From: Tybie House [REDACTED]
Sent: 29 June 2026 08:33
To: Neil Crowther
Cc: Karl Roberts
Subject: Re: A/44/26/PL
Attachments: _ocellaweb3ocellawebdocsplanningdv_pl_filesA_44_26_PL21-254-502E Drainage Construction Details-Sh2.pdf

Apologies for another email on the subject, but for the sake of visual clarification, please would you append the attached drawing to my previous email. I feel this helps to explain the necessary accommodation to volumes and areas of SA1.

Drawing Title
**DRAINAGE
CONSTRUCTION DETAILS (SHEET 2)**

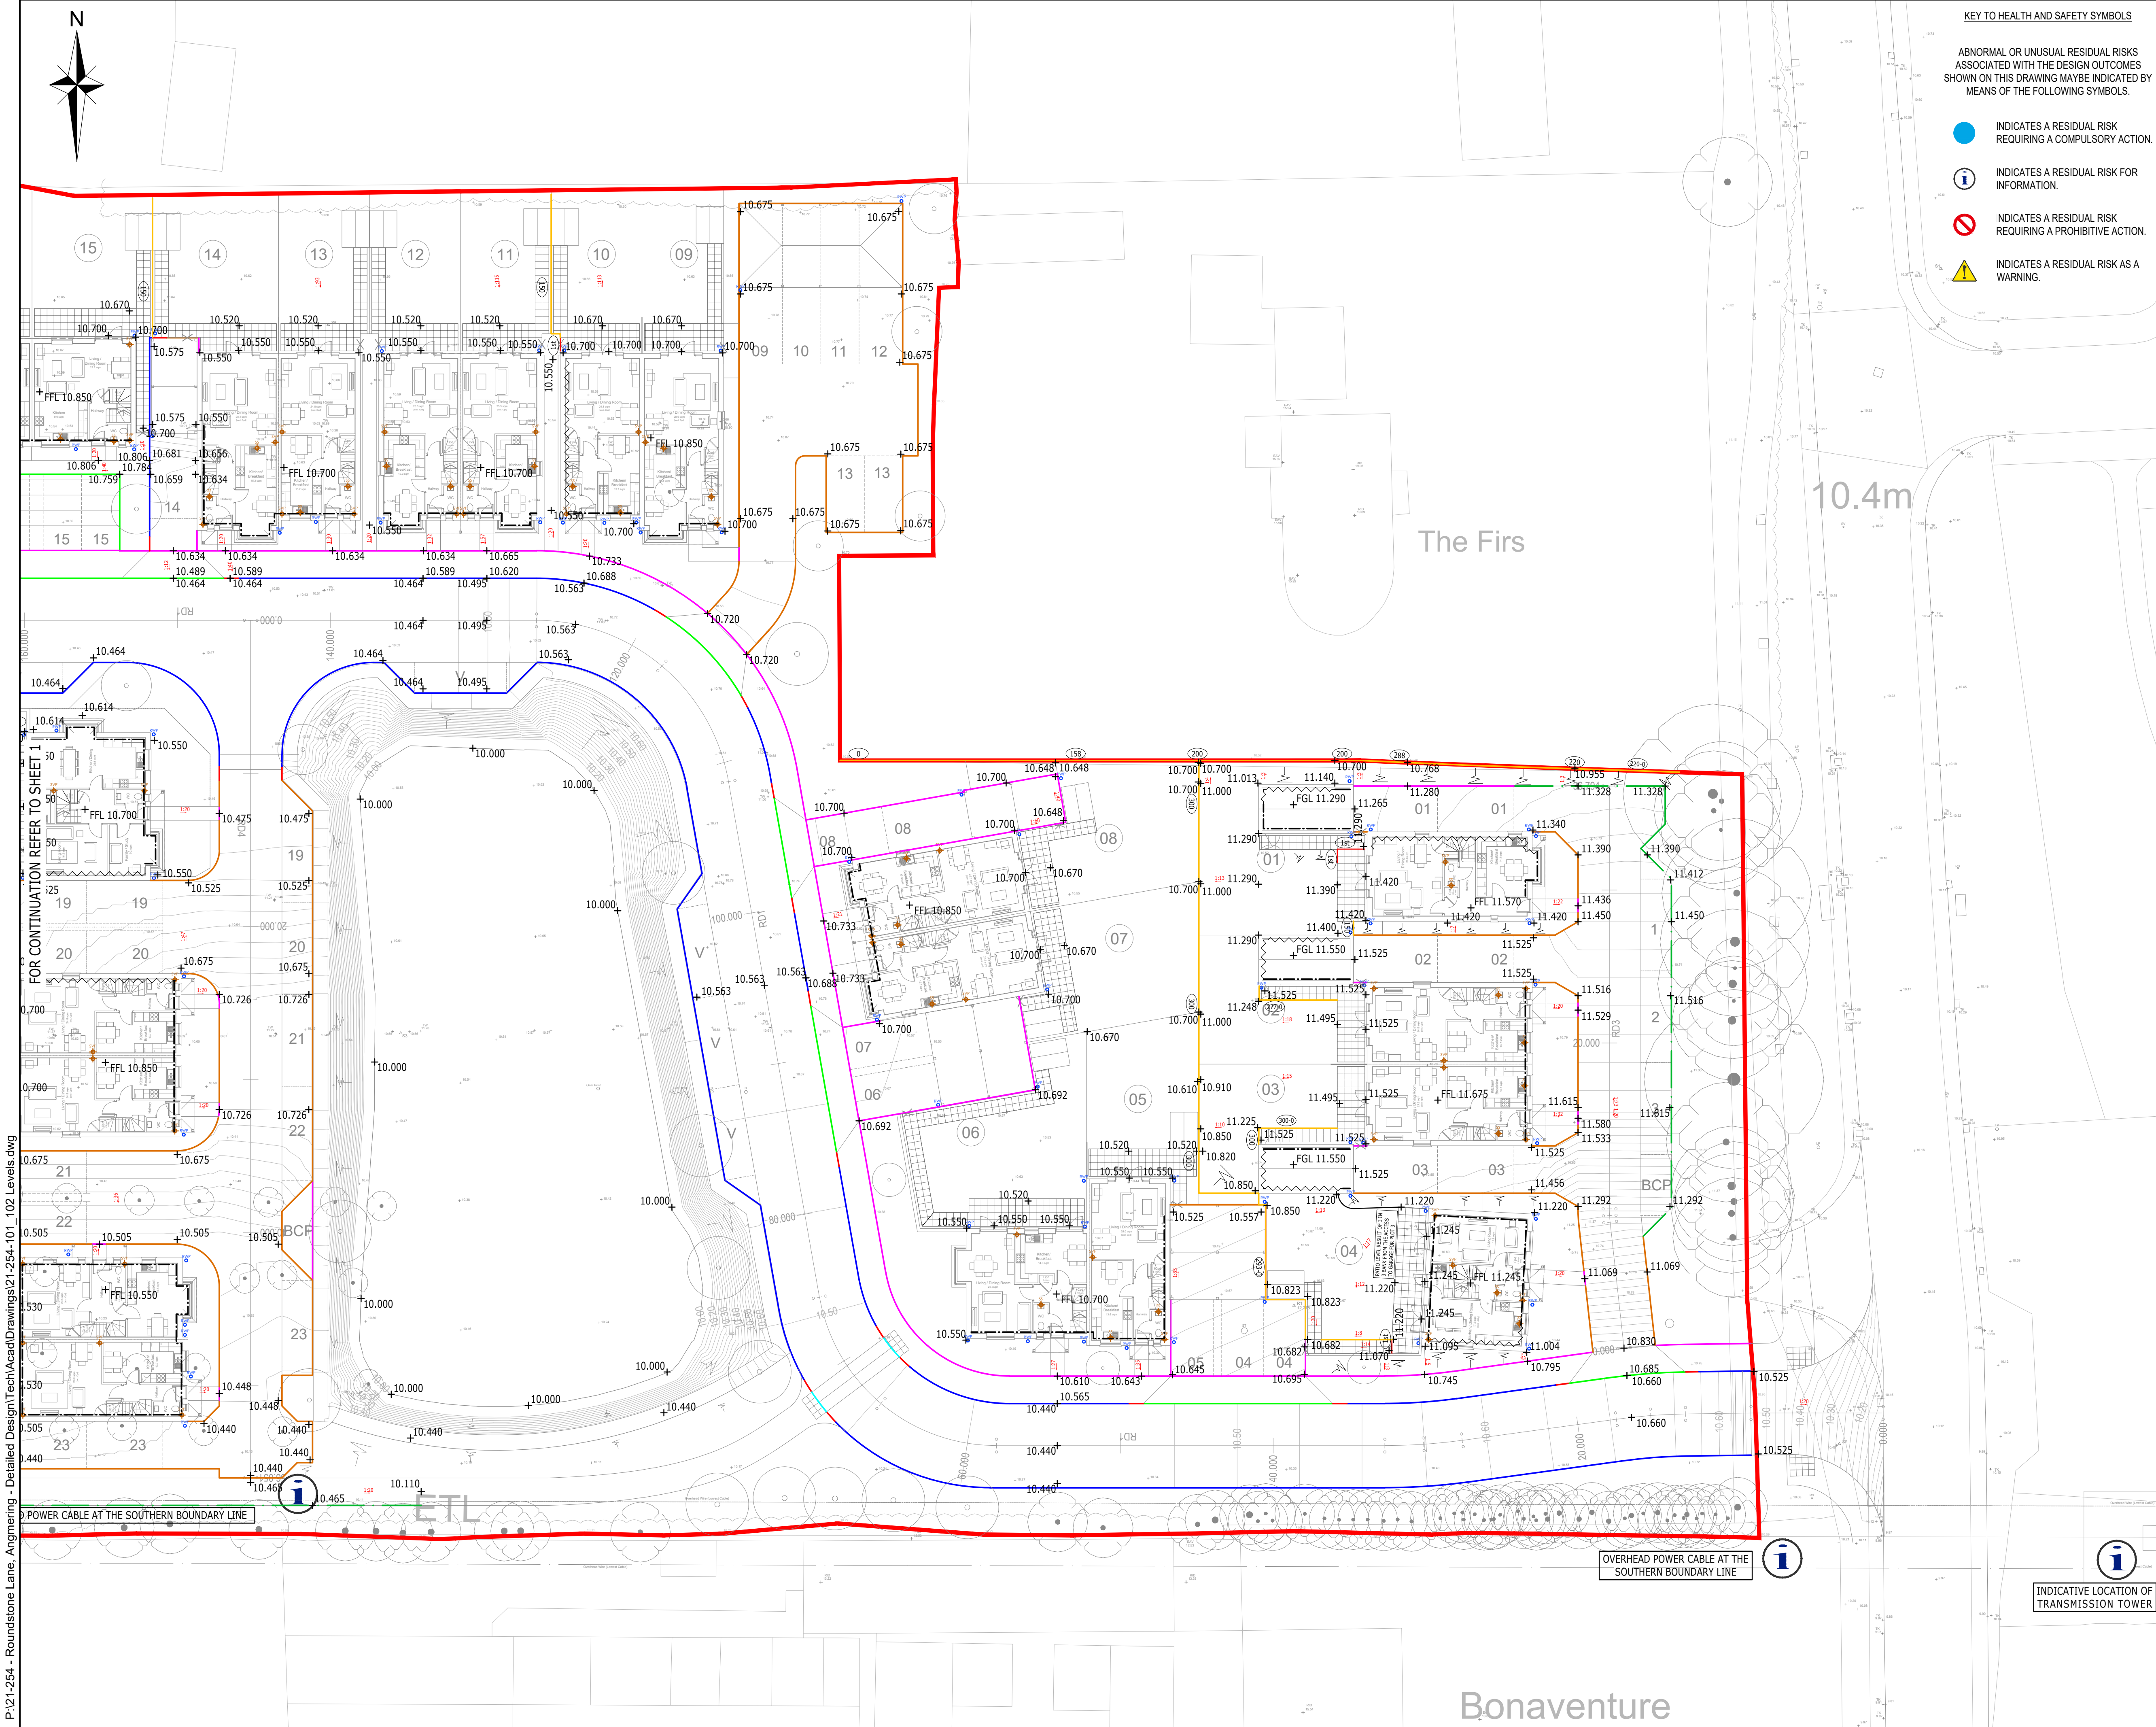
The RED volumes cannot contribute to storage as they are inspection chambers

The purple areas cannot contribute to infiltration as they are concrete and impermeable
